Re: 31 Fore Street BP# 2016600916

*Jean Fraser, Planner
City of Portland
874 8728*

DRAWING NO.
C-30

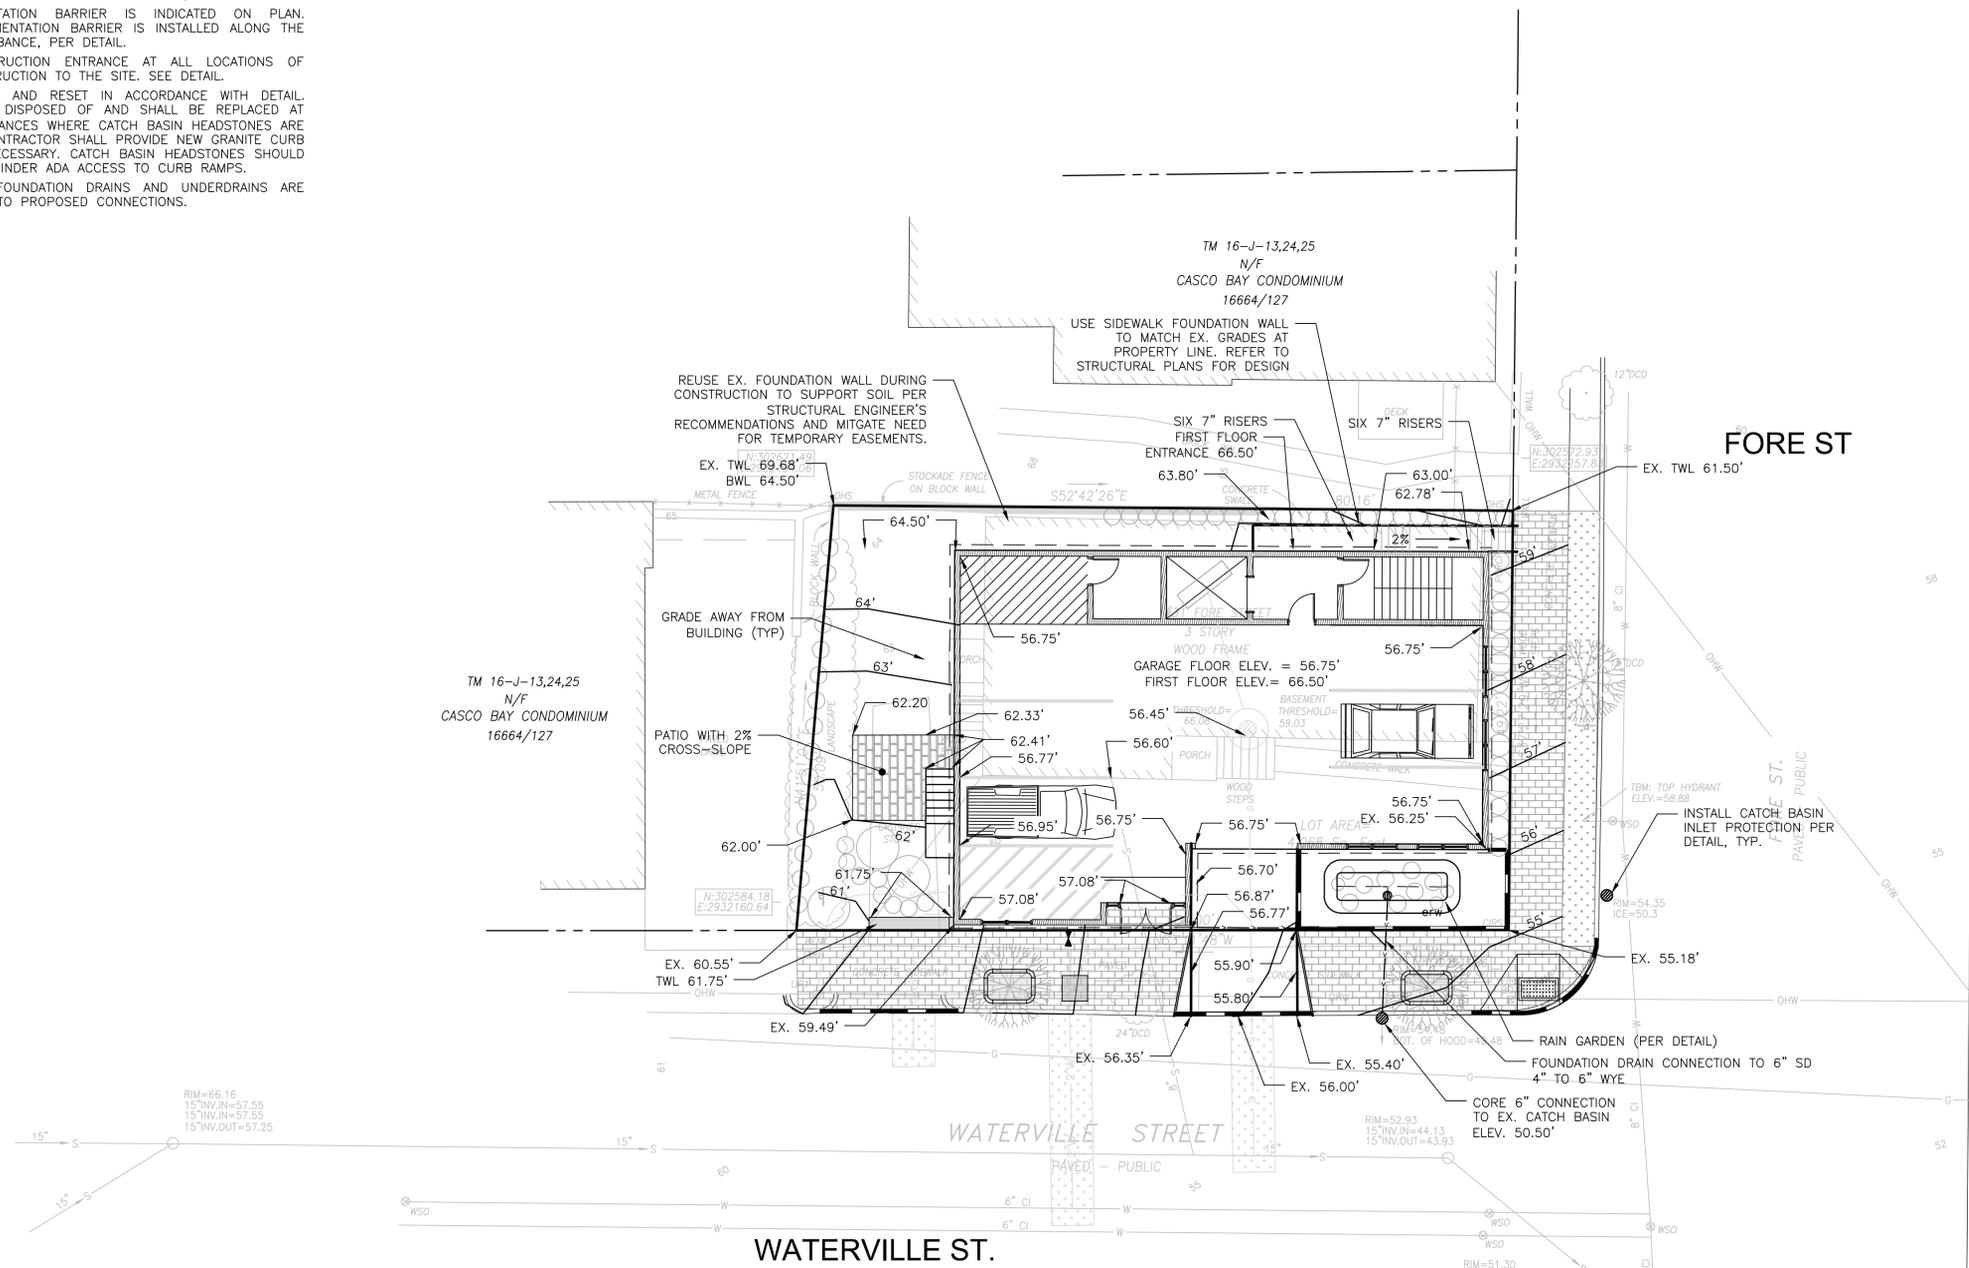
There is one more thing that needs to be clarified on the final plans so to meet ADA requirements - where a tip down ramp is being introduced into the sidewalk along Fore Street, on the corner nearest to the raingarden please make sure it meets ADA ie needs to have **3** feet between the curbing around the raingarden and the rear section of the ramp.

6. **Balconies and snow/ice onto sidewalk:** I note that it was confirmed that they would be sloped to the south to drain into the raingarden, but I had asked if the side overhanging the sidewalk would have a lip or something to keep "pushed"/"piled" (prior to melting) snow/ice from falling over the edge.

DRAWING NO.
C-01

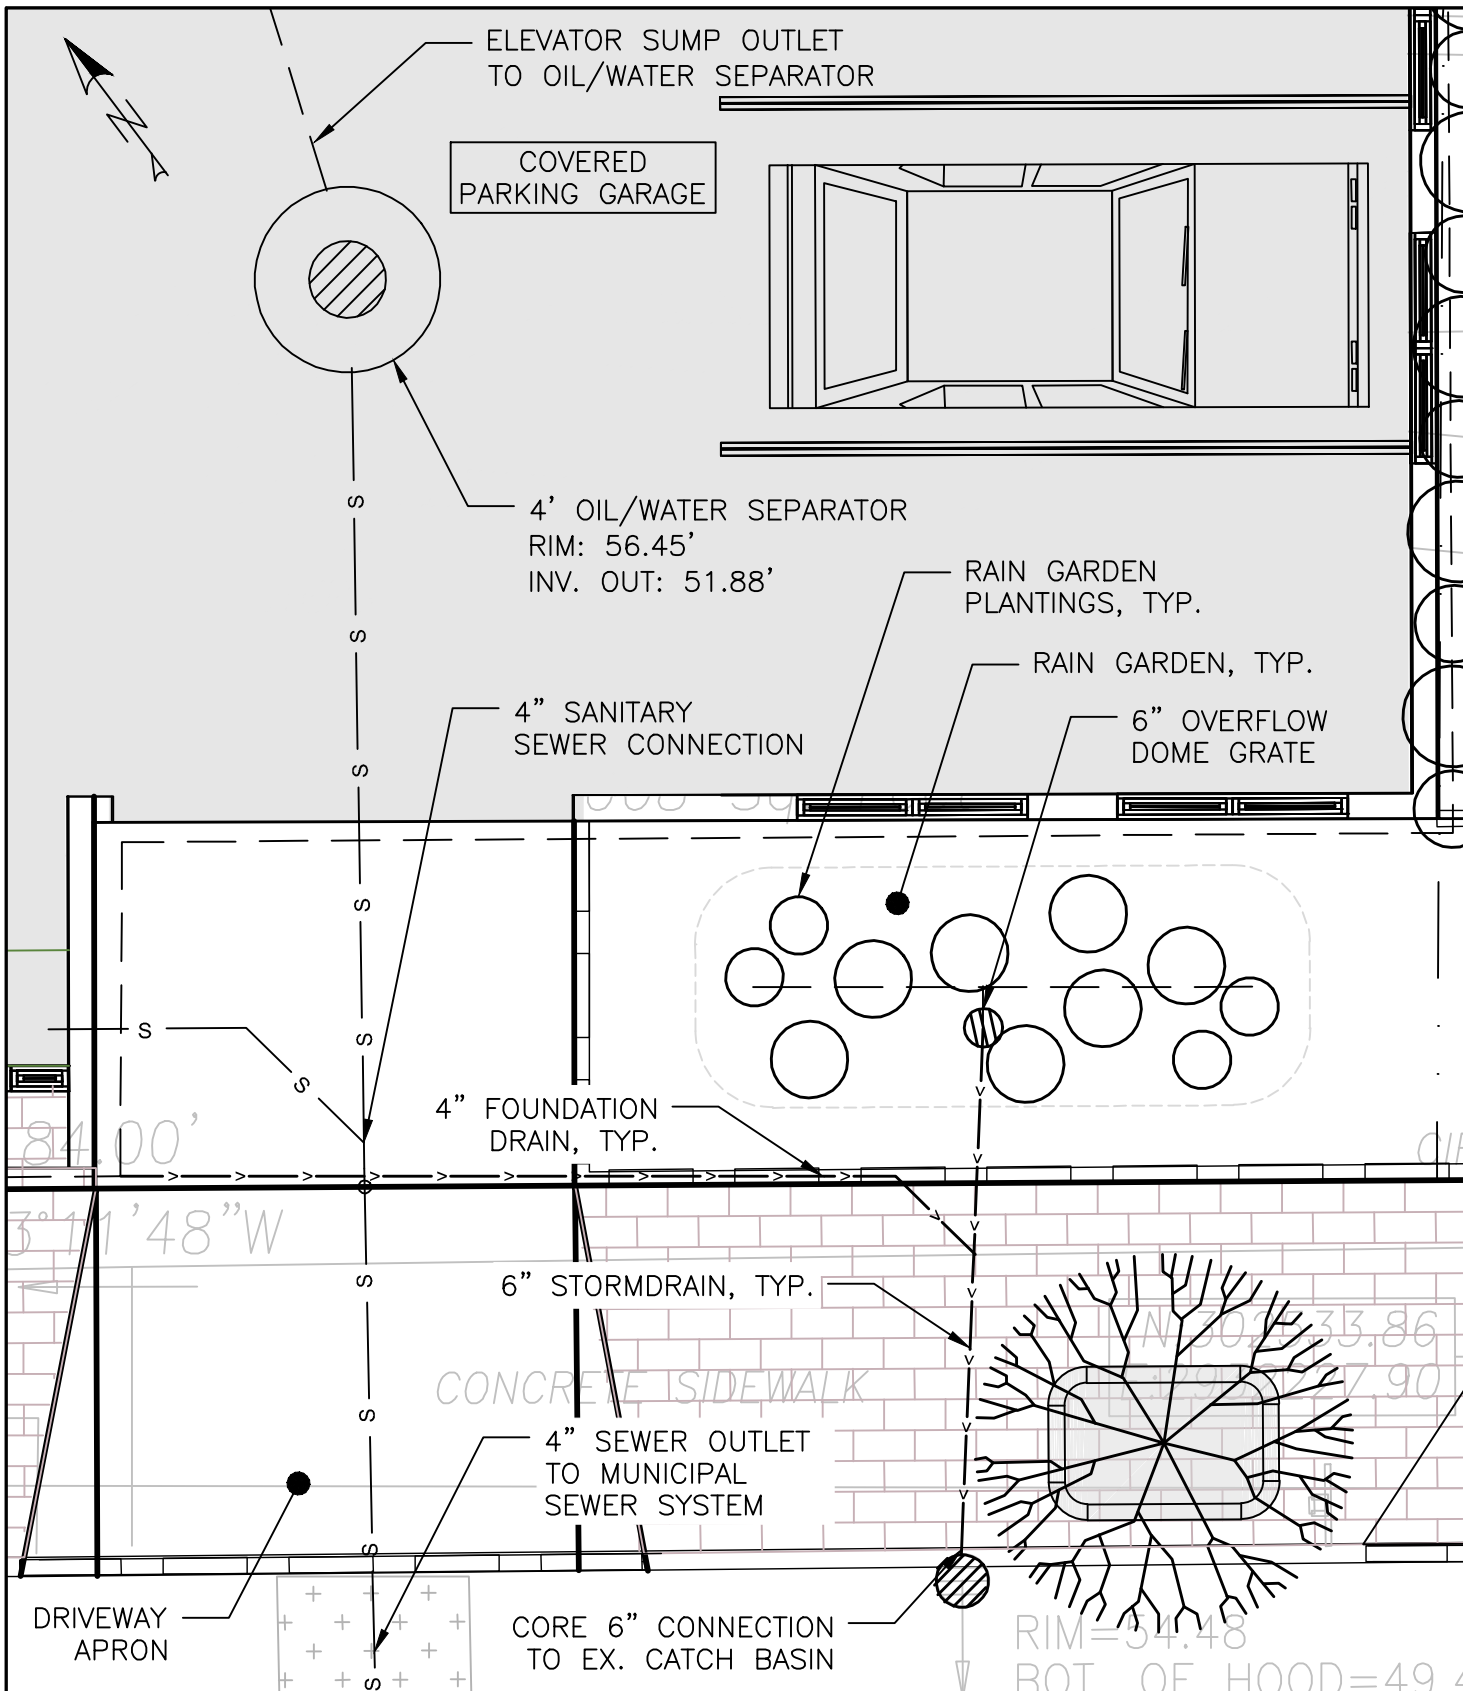
3. **Condo docs:** Revised version received 6.1.16 and is under review by Legal
4. **Stormwater Agreement:** (copy of what we received is attached): Please put in date of the Stormwater Man Plan and put in reference to the approved Drainage Plan (C-30 Rev dated 3.7.16) - not sure what C-01 is but it was not reviewed and approved. The final agreement with the Stormwater Main Plan and Grading Plan attached should be signed and recorded and then a copy of the recorded doc sent to me. If this is the only item outstanding, we won't hold up the BP for this.

Drawing file: approved REc'd 5.16.16 with new doghouse / 31 FORE ST A2.1 - ELEVATIONS 5-16-16.pdf

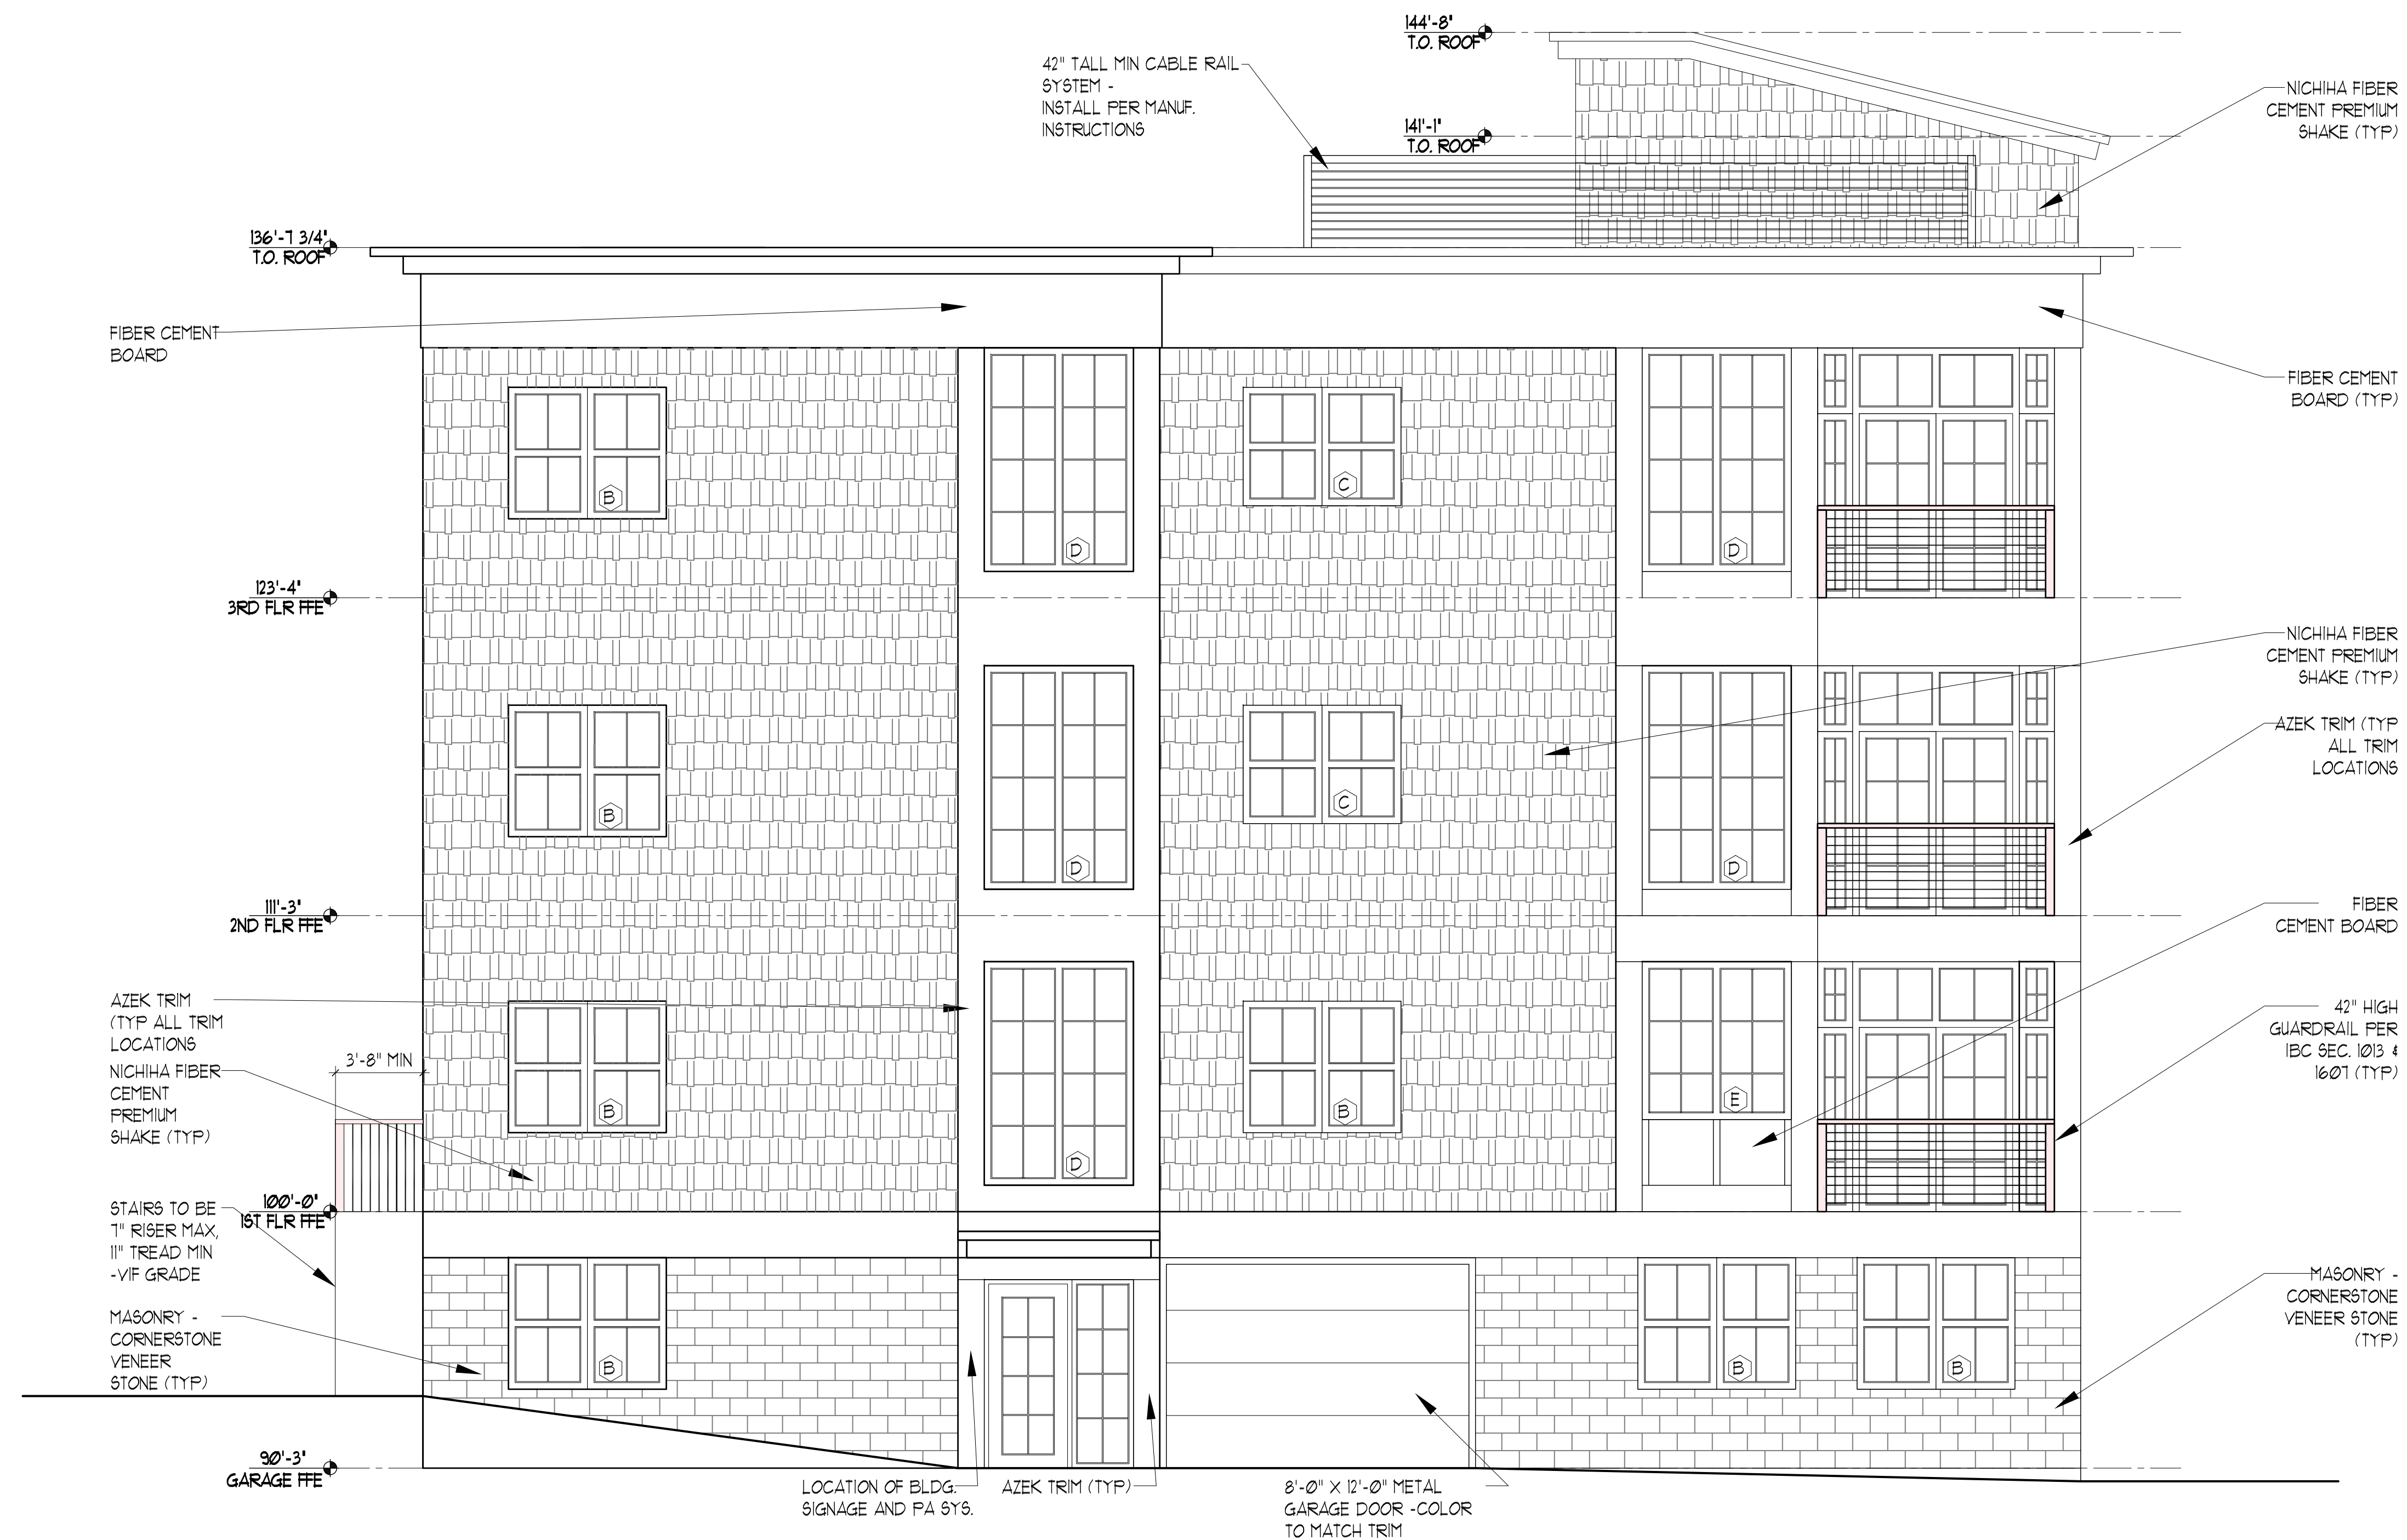
1. **Site Plan Amendment re doghouse**- discussed with Bob and when we receive the documenting e-mail, others here will resolve; make sure revised plan is sent to Building inspections to be included in their review as I expect it will be approved;

Please note that this project was subject to an R6 Design Review and the Board approved specific materials and design elements eg windows, cladding materials etc. Any changes to these would constitute site plan amendments and would need to be advised to me and I would arrange for review and approval to any amendments. The window changes seen in the BP submissions are OK.
